Great North Road Solar and Biodiversity Park

Draft Statement of Common Ground with Nottinghamshire County Council

Document reference – EN010162/APP/8.1A

0 0.25 0.5 1 km

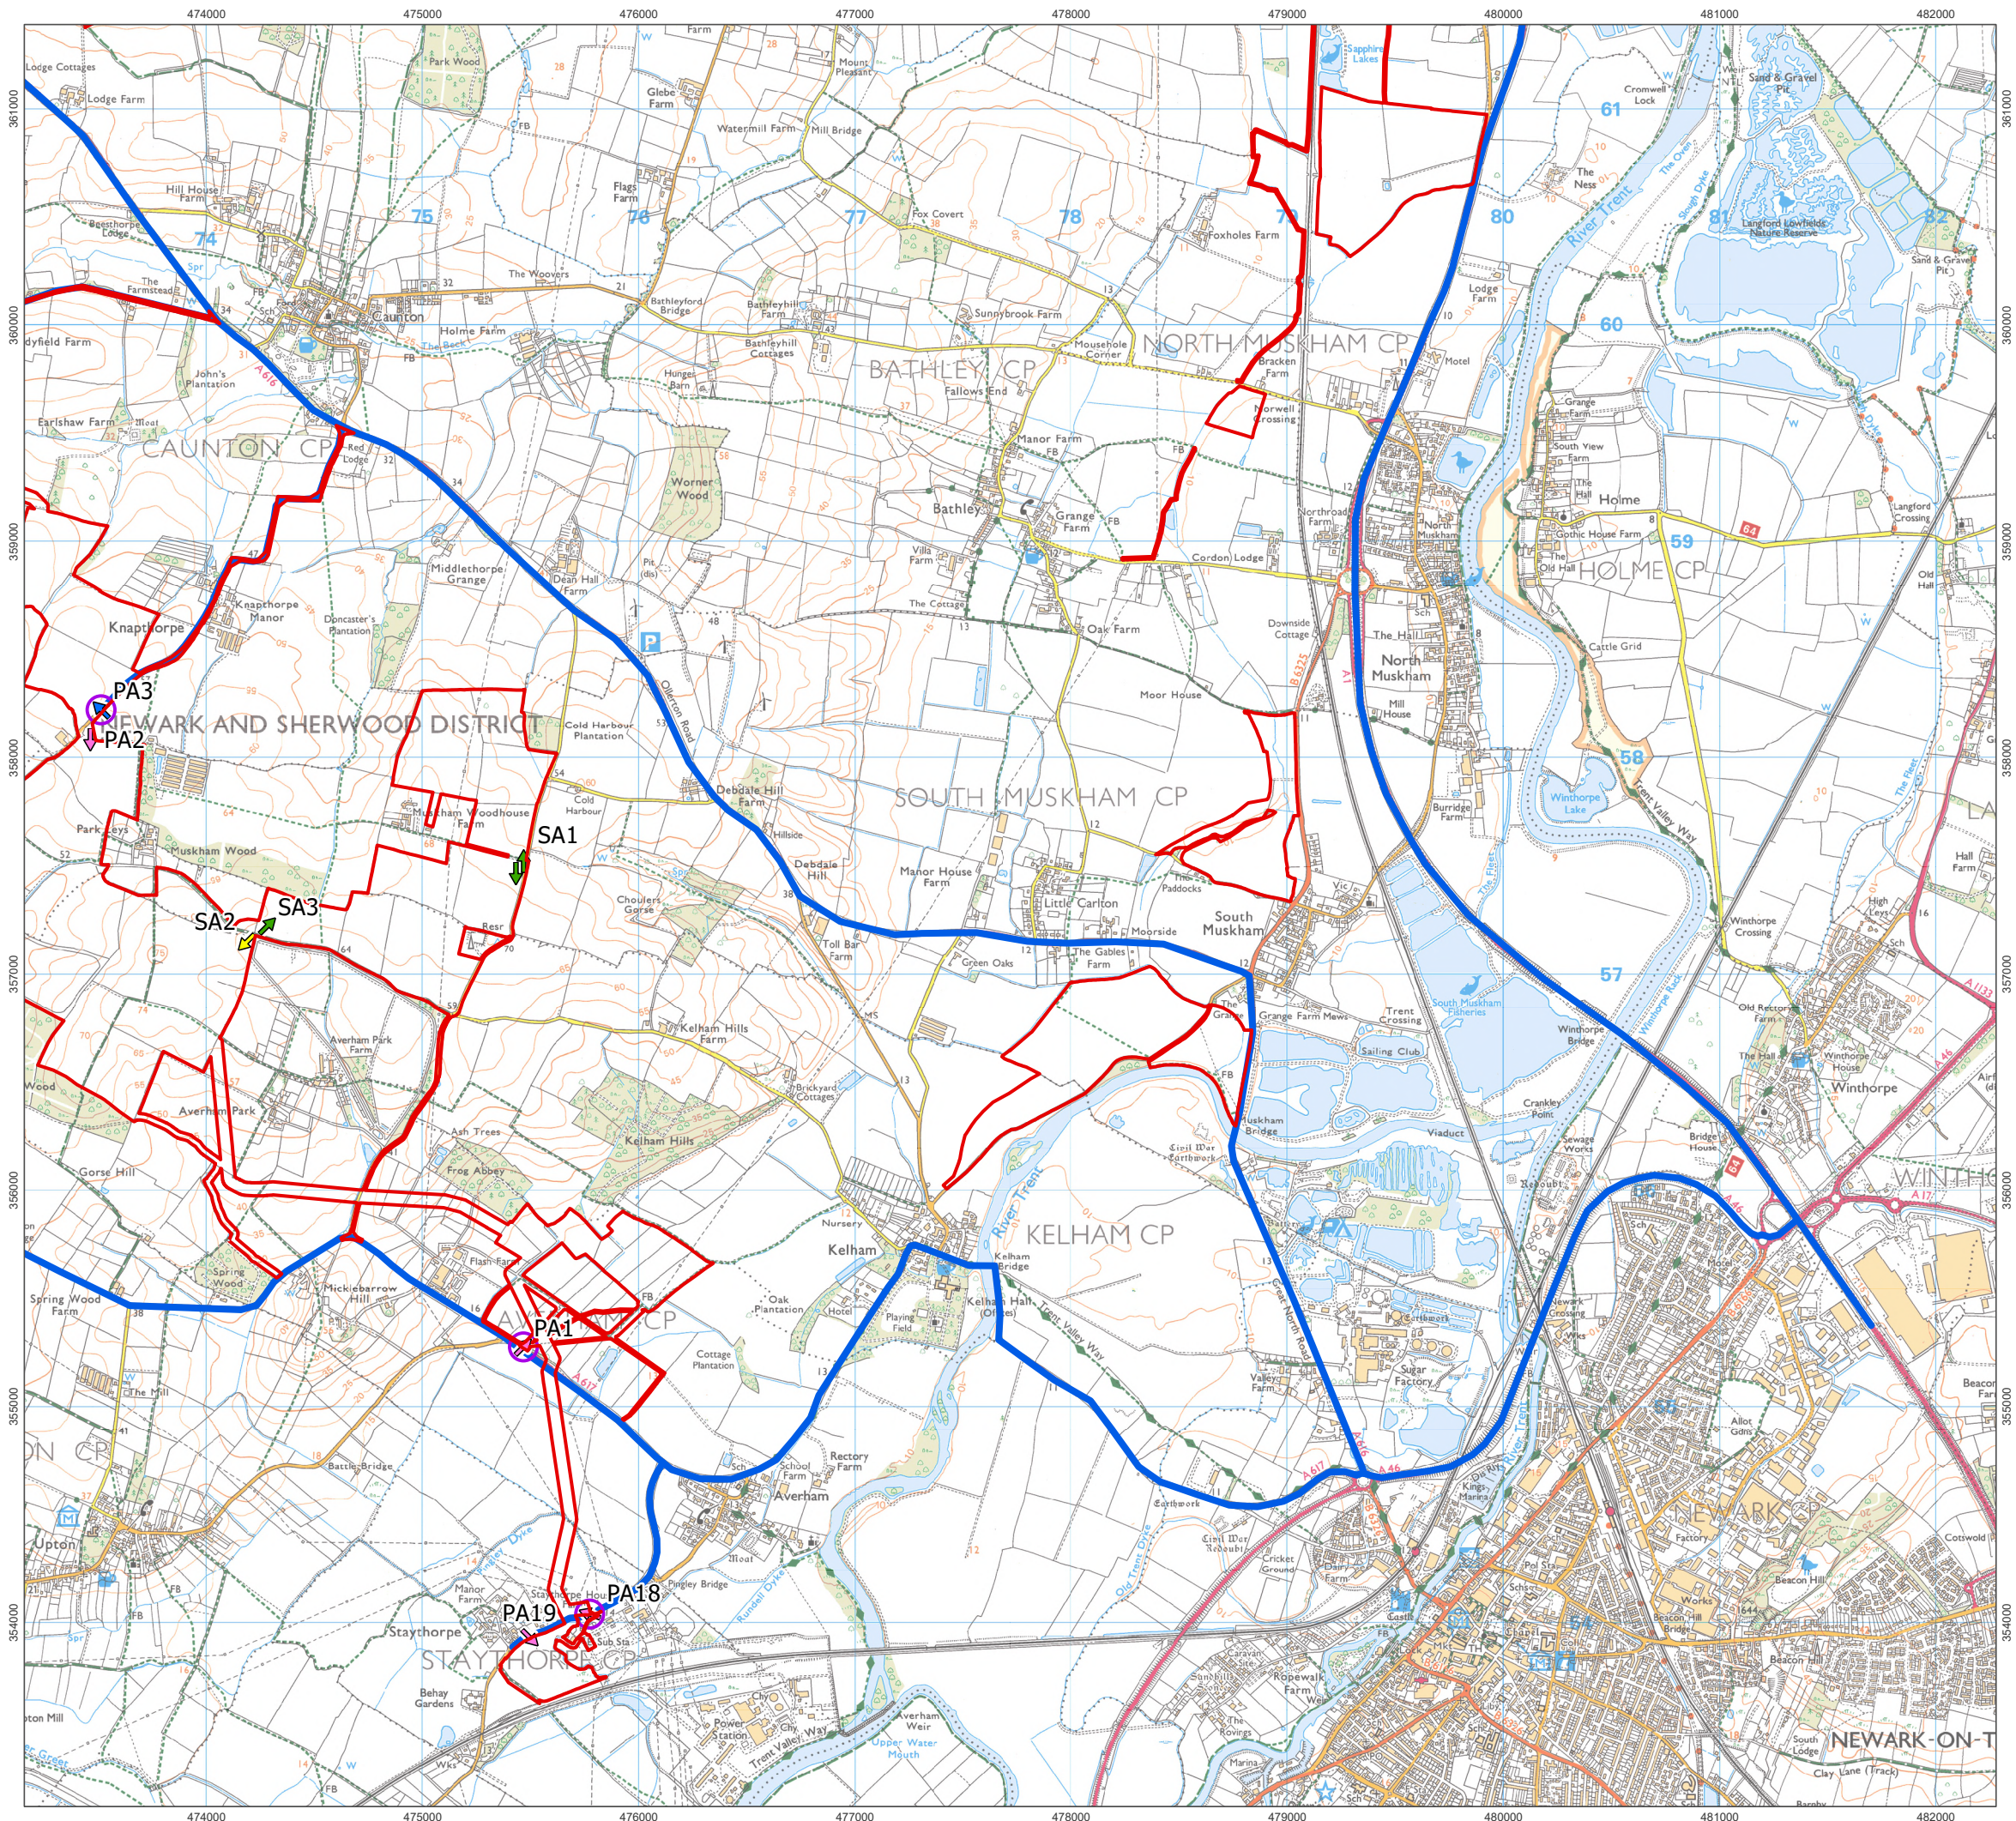
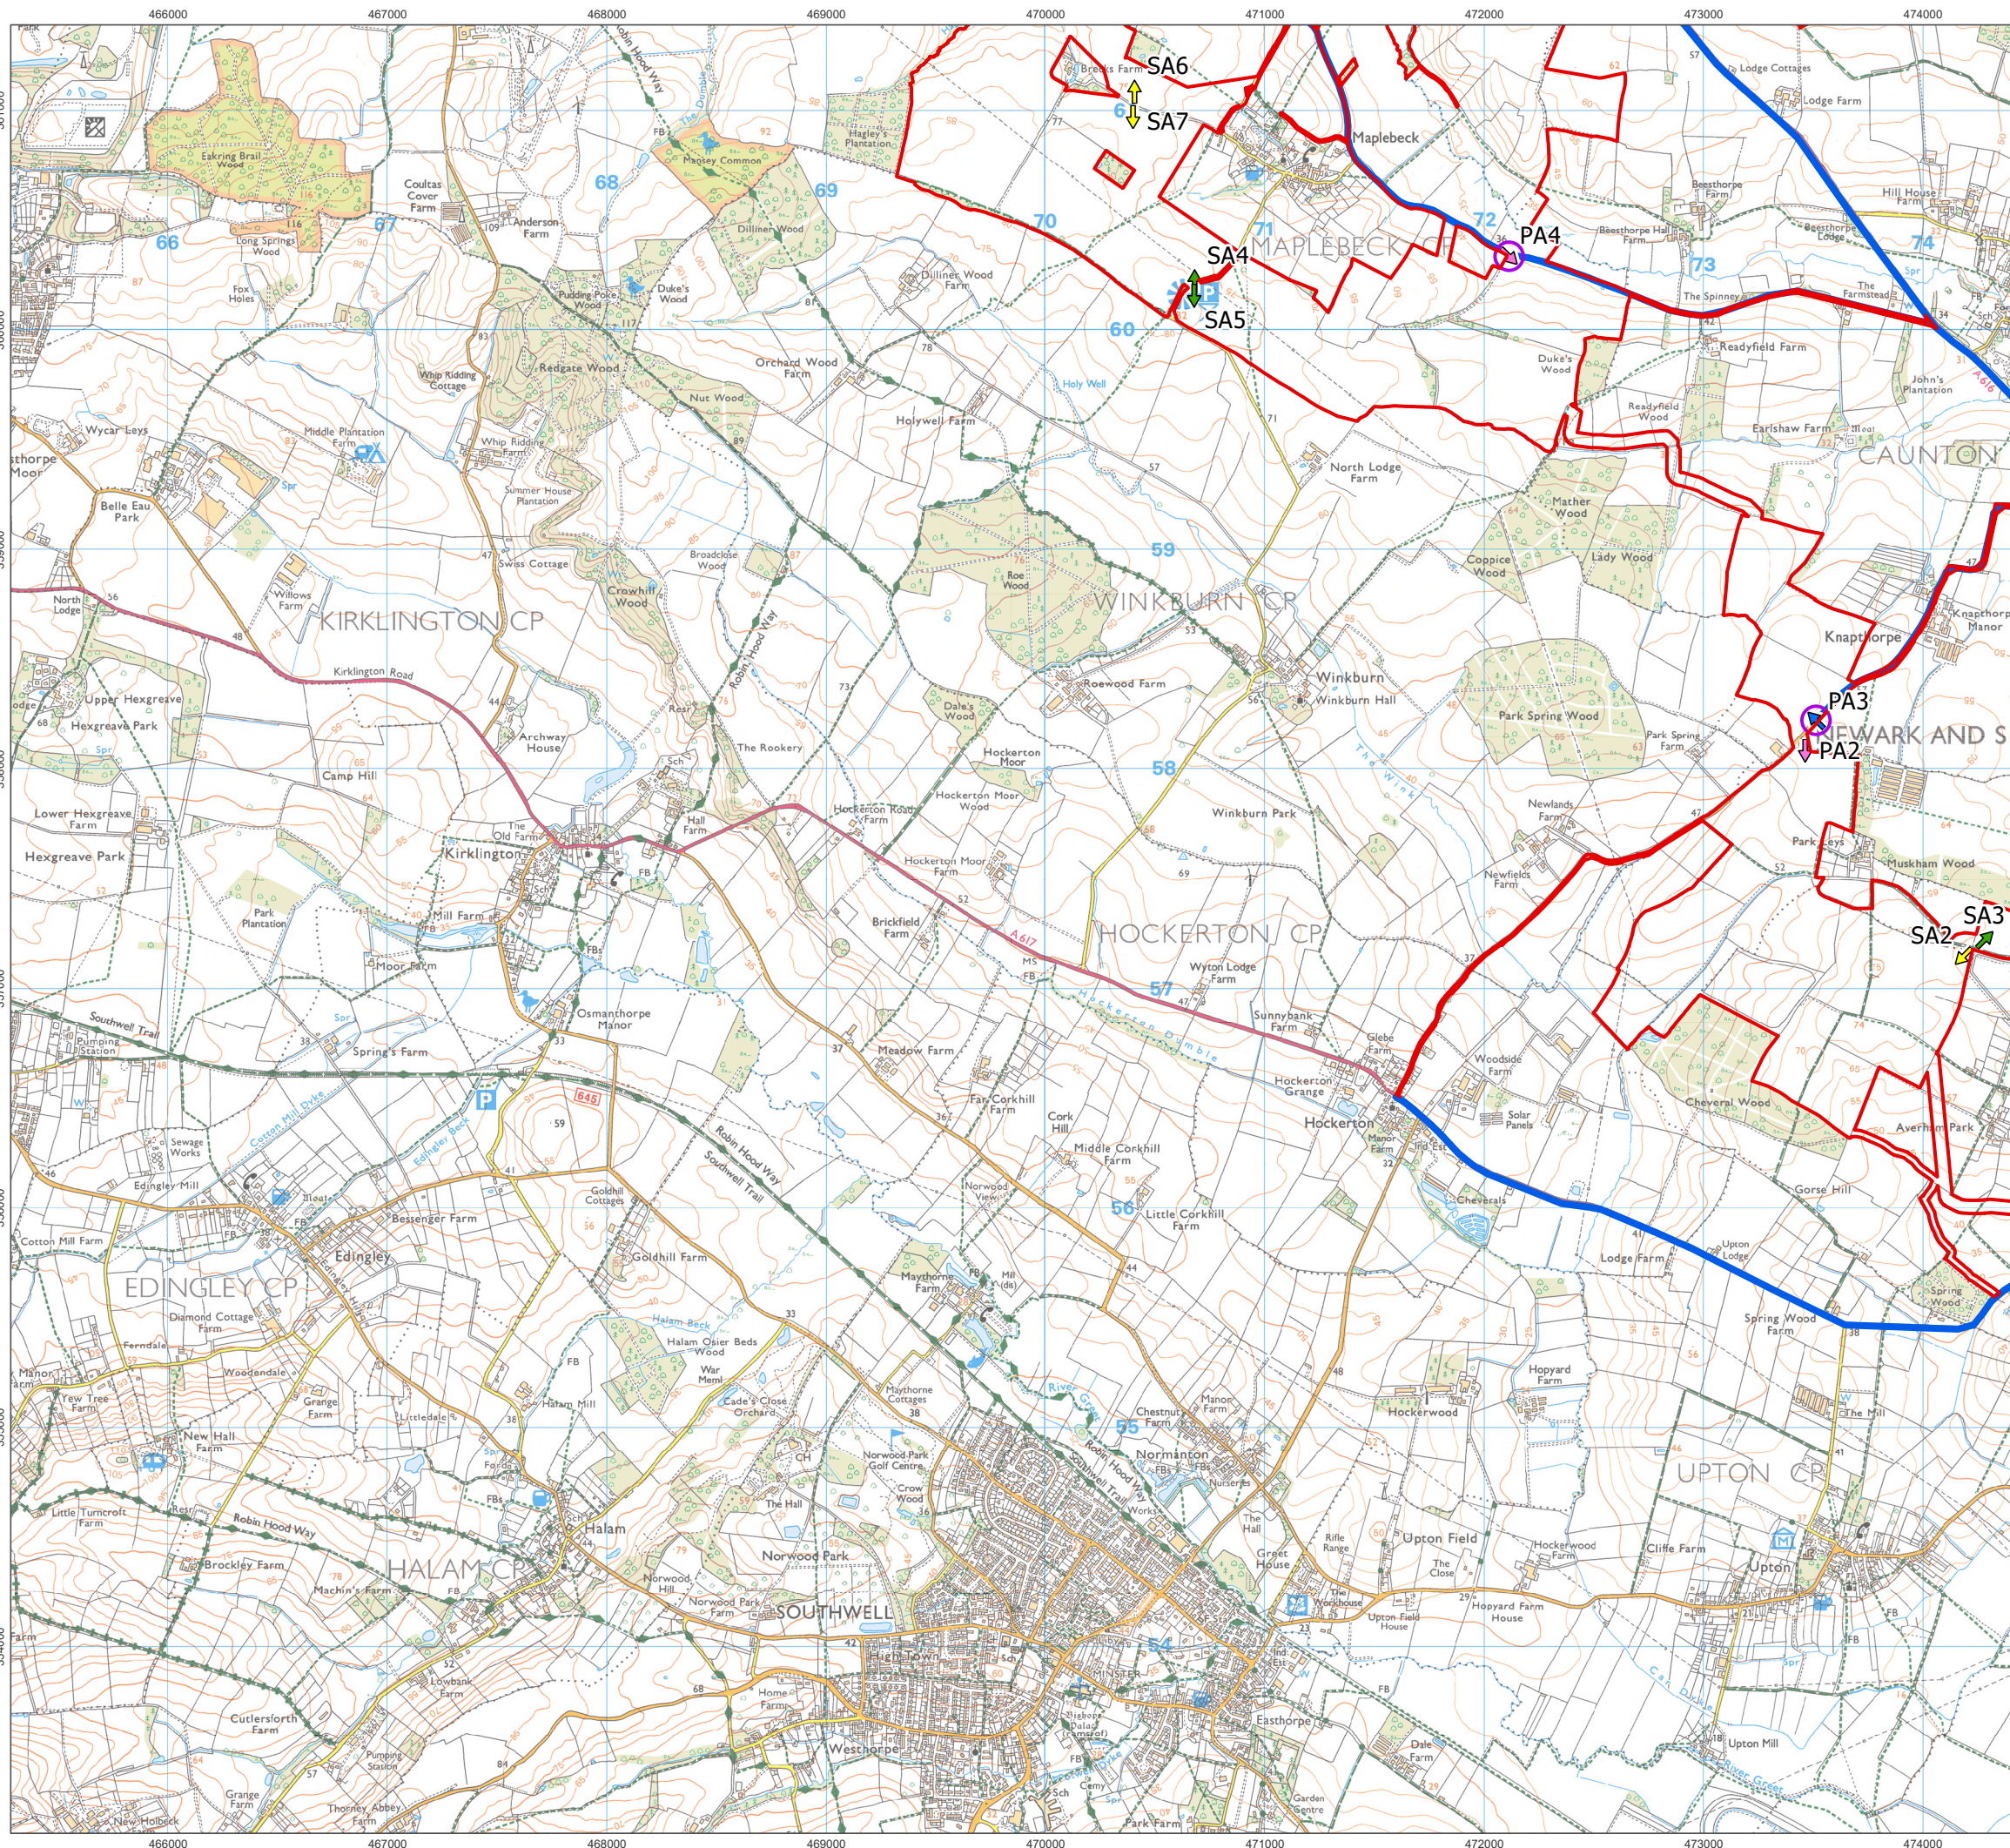
Ref	Document Reference	Description of Matter	Applicant's Position	NCC's Position	Status
				to apply such optimistic discounts.	
2.5.8	RR	Accesses	The Access Routes Hierarchy is shown in ES Volume 3, Figure 5.1: Works Areas [EN010162/APP/ 6.3.5B]. The Site Access locations are then shown at ES Volume 3, Figure 14.4: Site Access Locations [EN010162/APP/6.3.14A] and ES Volume 3, Figure 14.5: Passing Place Locations [EN010162/APP/6.3.14A]. ES Volume 4, Appendix A14.1: Transport Statement [EN010162/APP/6.4.14.1A] Appendix D provides the site access designs, including their form, key dimensions and demonstrates their suitability through swept path analysis of the largest anticipated HGV entering and exiting each respective location. This analysis of the construction access points confirms that they can be designed to meet relevant design standards. The Applicant will engage with NCC (the Local Highway Authority) to provide any further information, including the timing of Road Safety Audits.	No consideration to the form of access appears to have been given. The traffic information supplied identifies that a number of the accesses trigger the requirement in DMRB CD123 for further assessment, during both the construction and operational phase. Where only occurring in the construction phase, mitigation in the form of traffic management may be acceptable, but locations where this would be required should be identified. Information regarding the number of HGVs at each access was requested, and whilst information in Appendix F provides a breakdown, it is difficult to link the	Under Discussion

Ref	Document Reference	Description of Matter	Applicant's Position	NCC's Position	Status
				accesses in here to those described elsewhere and therefore clarity is required. Whilst a statement is made that the access drawings are outline drawings and detailed designs will be forthcoming at the appropriate time, the principle of acceptability needs to be established. There are a number of accesses, either proposed or amended (with increased usage) which have apparent highway safety concerns. All new or amended accesses should therefore be subject to a Stage 1 Road Safety Audit, as required by the Nottinghamshire Highway Design Guide, to inform this process.
